**Application** H09-1278-25  
**Location** Land East of Forest Way Holbeach Spalding  
**Proposal** Proposed Erection of 2 Bungalows

**Name** National Grid Electricity Distribution  
**Address** formerly Western Power Distribution

PROPOSED SITE PLAN
scale 1:200

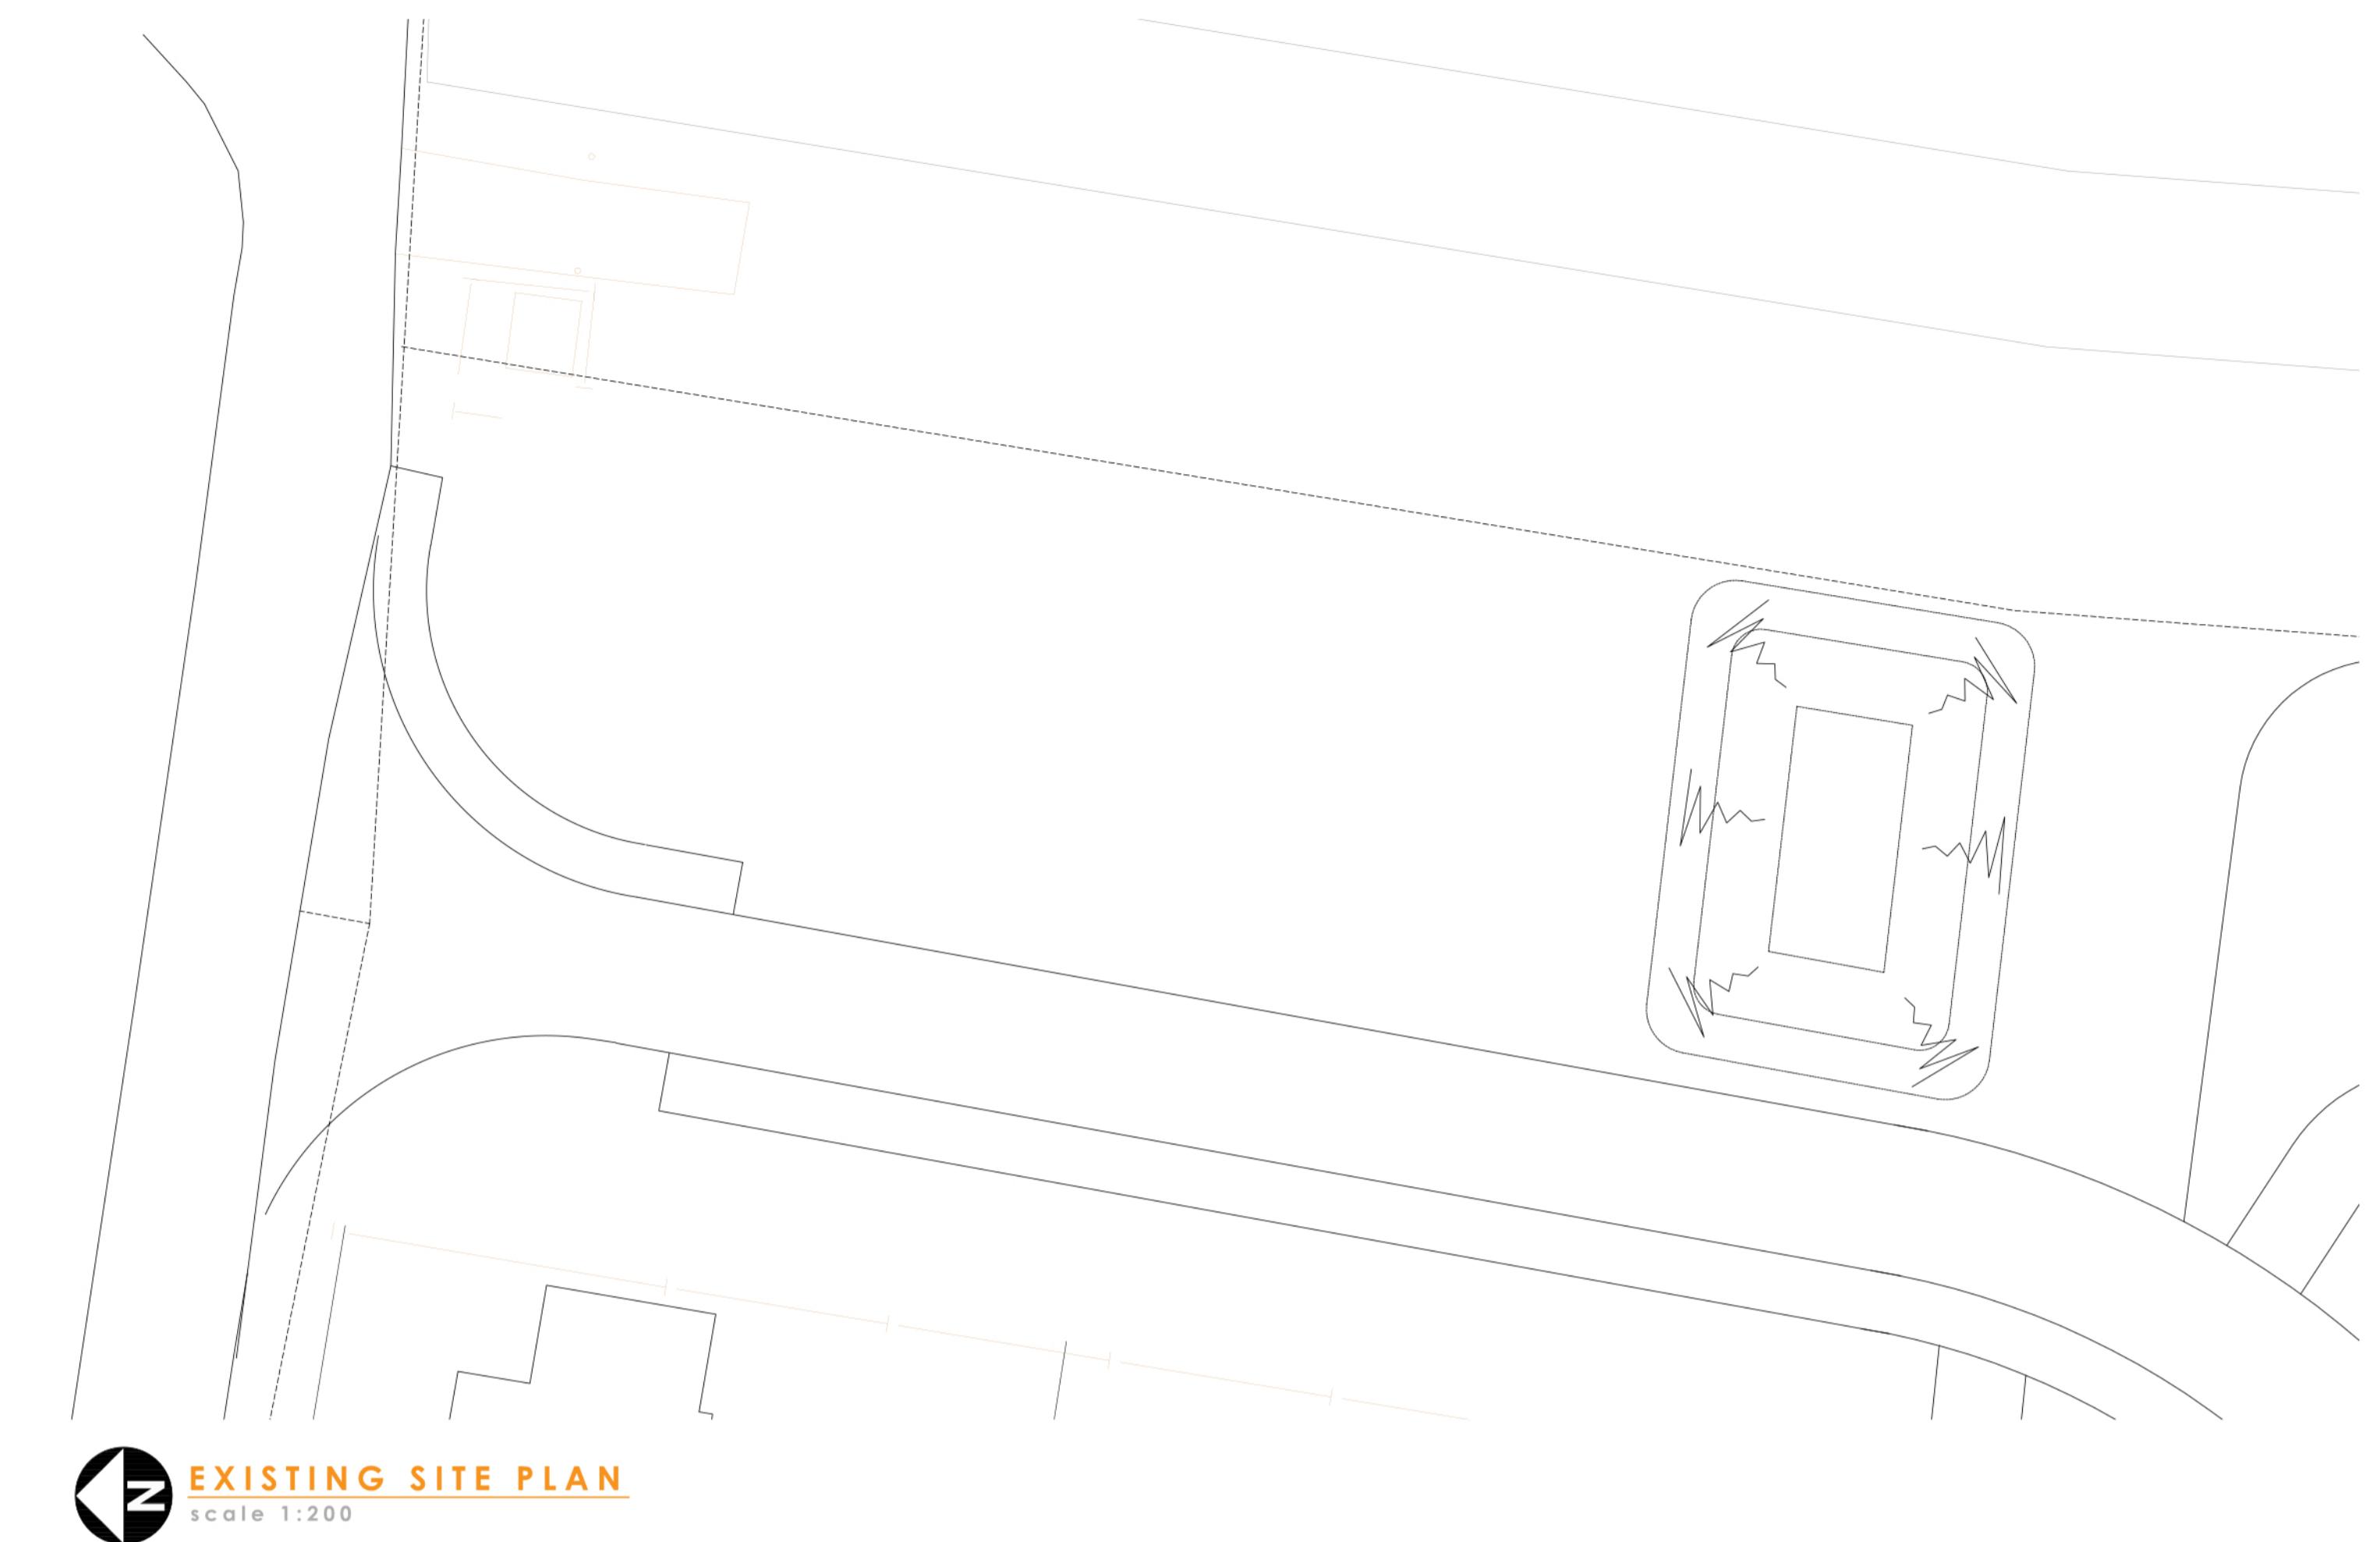
Please contact NGED Planning to check the surrounding UG earthing and cables are 9m clear of development.
